Application by Able Humber Ports Ltd for Able Marine Energy Park Material Change 2
The Examining Body's written questions and requests for information (ExQ1)
Issued on 19 November 2021

Responses are due by Deadline 1: 14 December 2021 at 23:59

Project: ABLE Marine Energy Park  
 Client: ABLE UK Limited  
 Drawing Title: Section A for Quay Typical Section

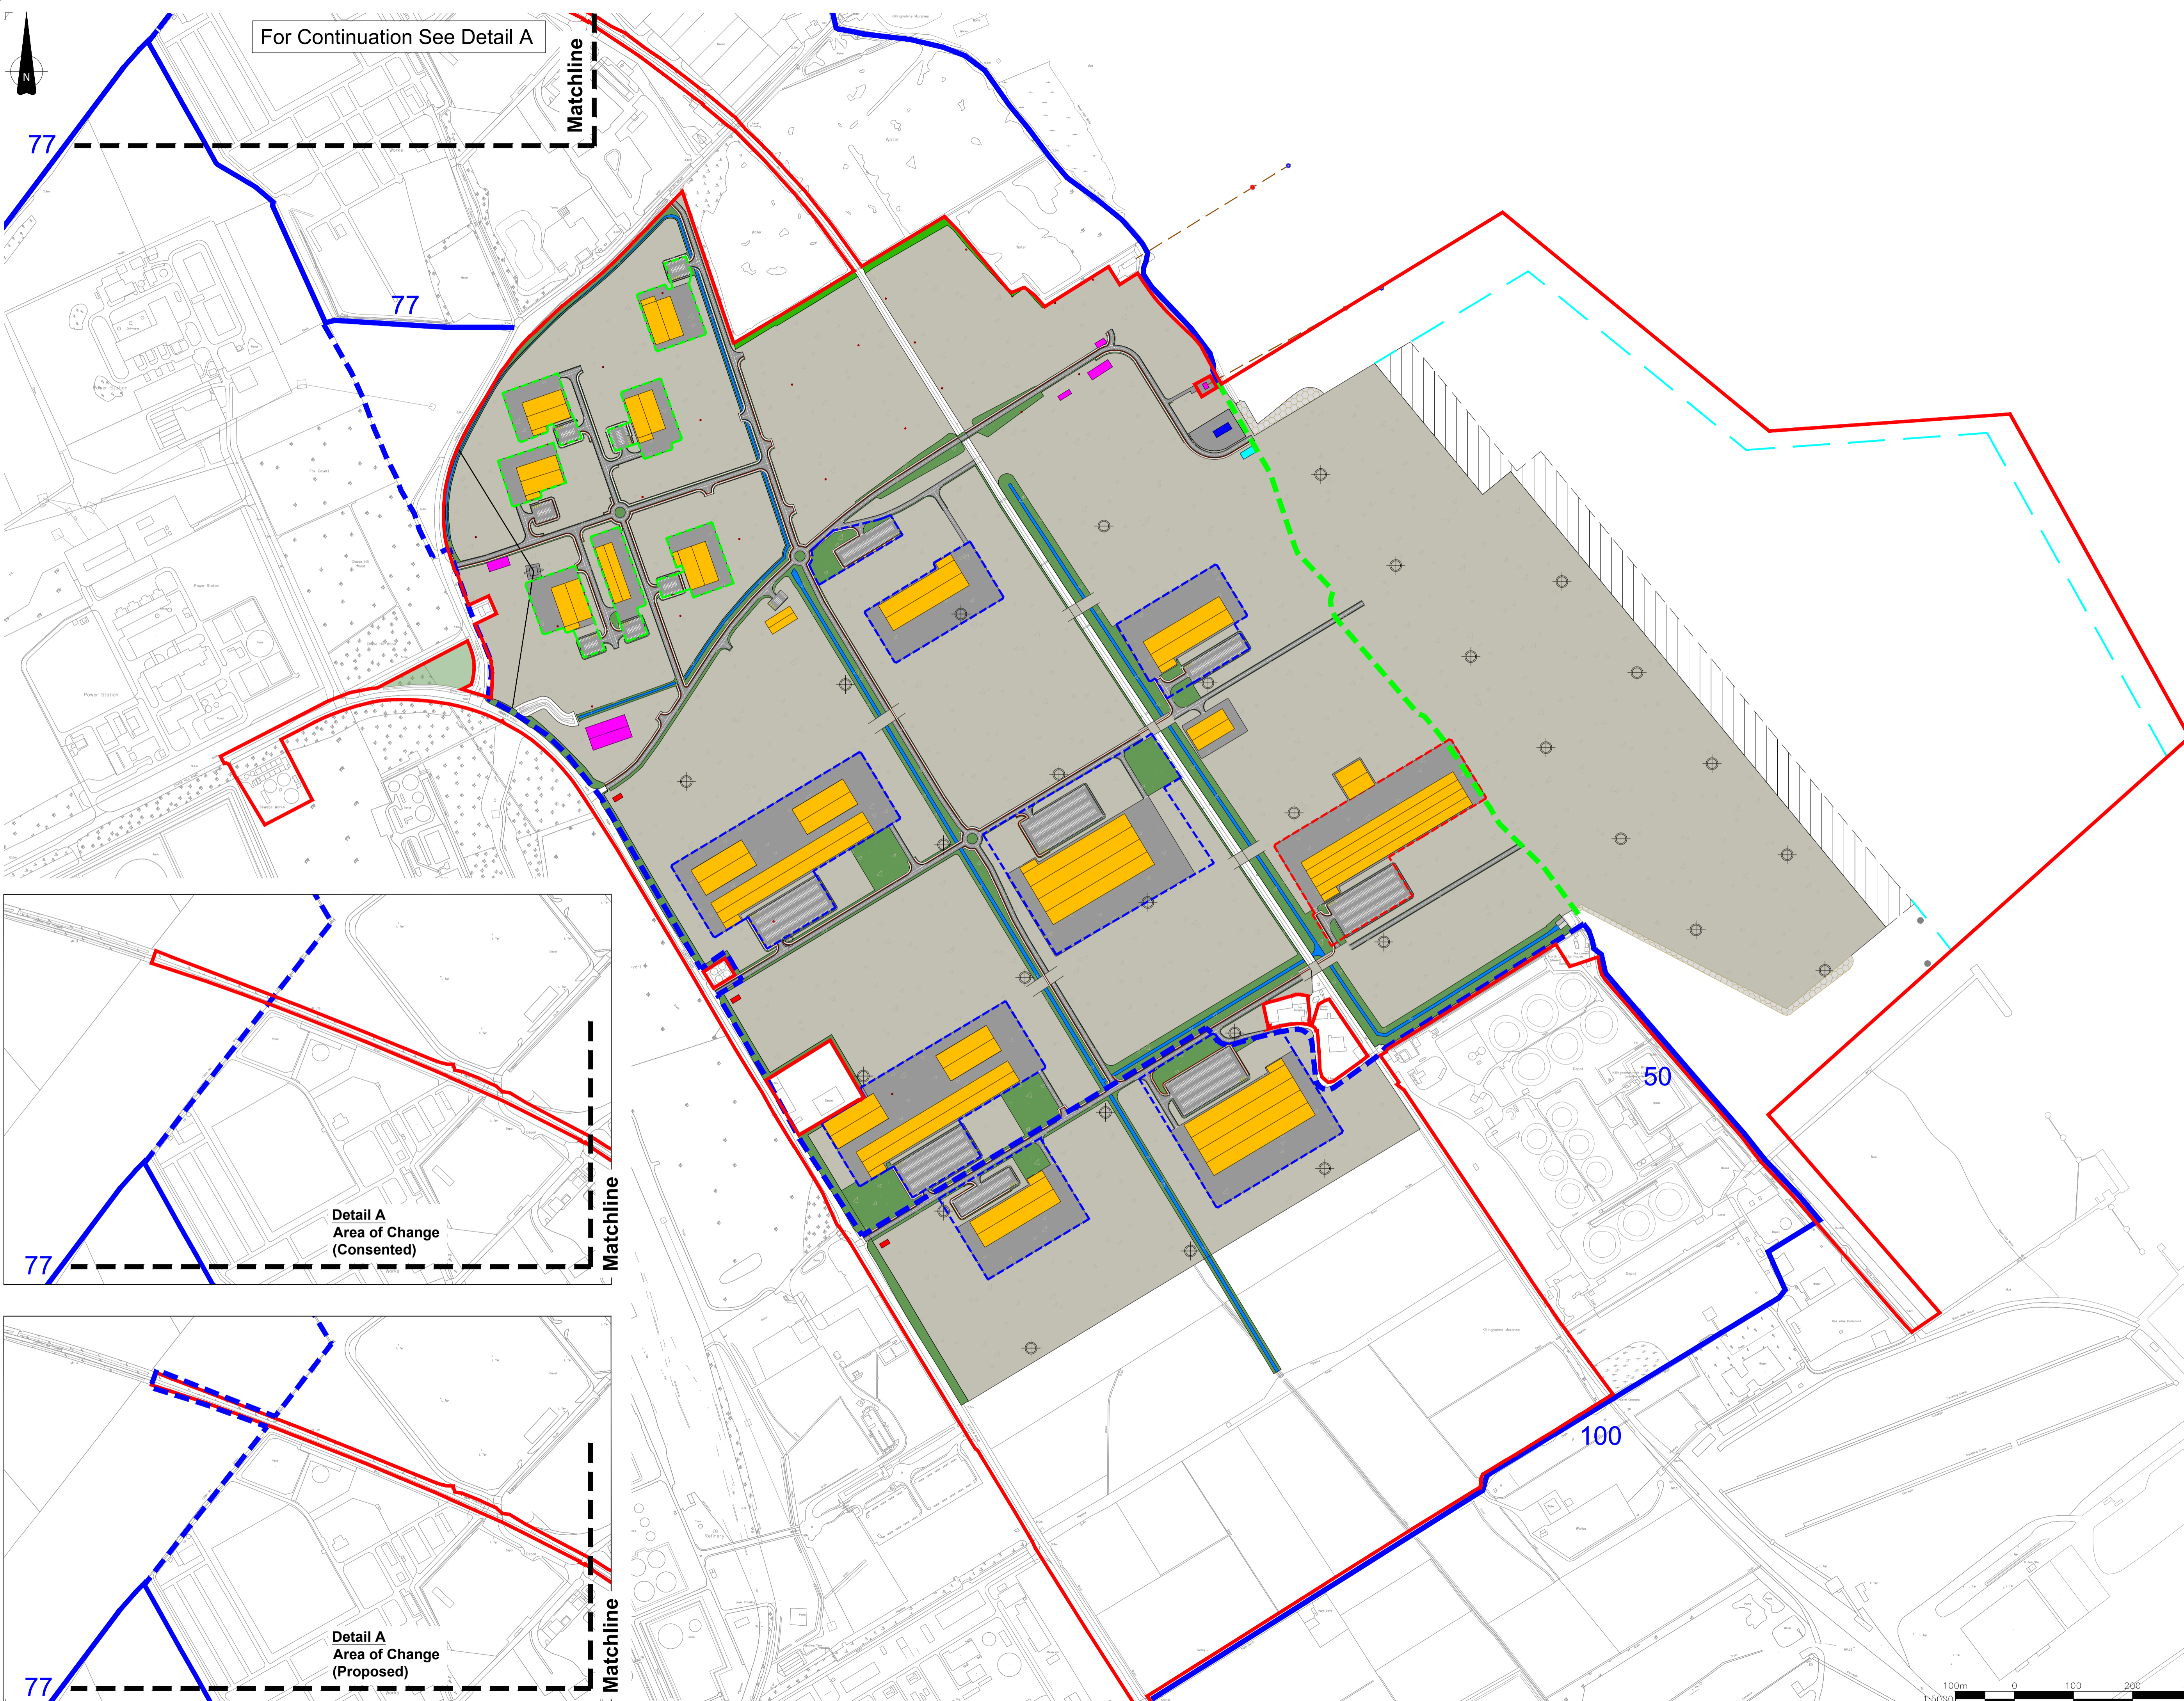
ExQ1	Question to:	Question:
1. General and Cross-topic Questions		
Q1.0.1	App	Please supply A3 size paper copies of all the current drawings associated with the Proposed Changes.
Q1.0.2	App	Does the Application involve two alternative approaches to construction of the quay in cross-section, as shown on drawing AME-036-00003 rev C, or three alternative approaches as shown on drawing AME-036-10004 Rev B? Under what circumstances would each alternative proceed?
Q1.0.3	App	Re: drawing AME-036-0003 rev C, no crane rail is shown in the Optional Design Section. Is this because the thicker RC slab would allow flexible crane location?
Q1.0.4	App	How would the number and diameter of piles vary in the alternative approaches?
Q1.0.5	App	Is the option available of using augered rather than percussion piles to reduce noise and disturbance?
Q1.0.6	App	Please develop UES 16.4 to show in detail that the ES envelope related to noise and disturbance covers all piling options, whatever the number and diameter of piles.
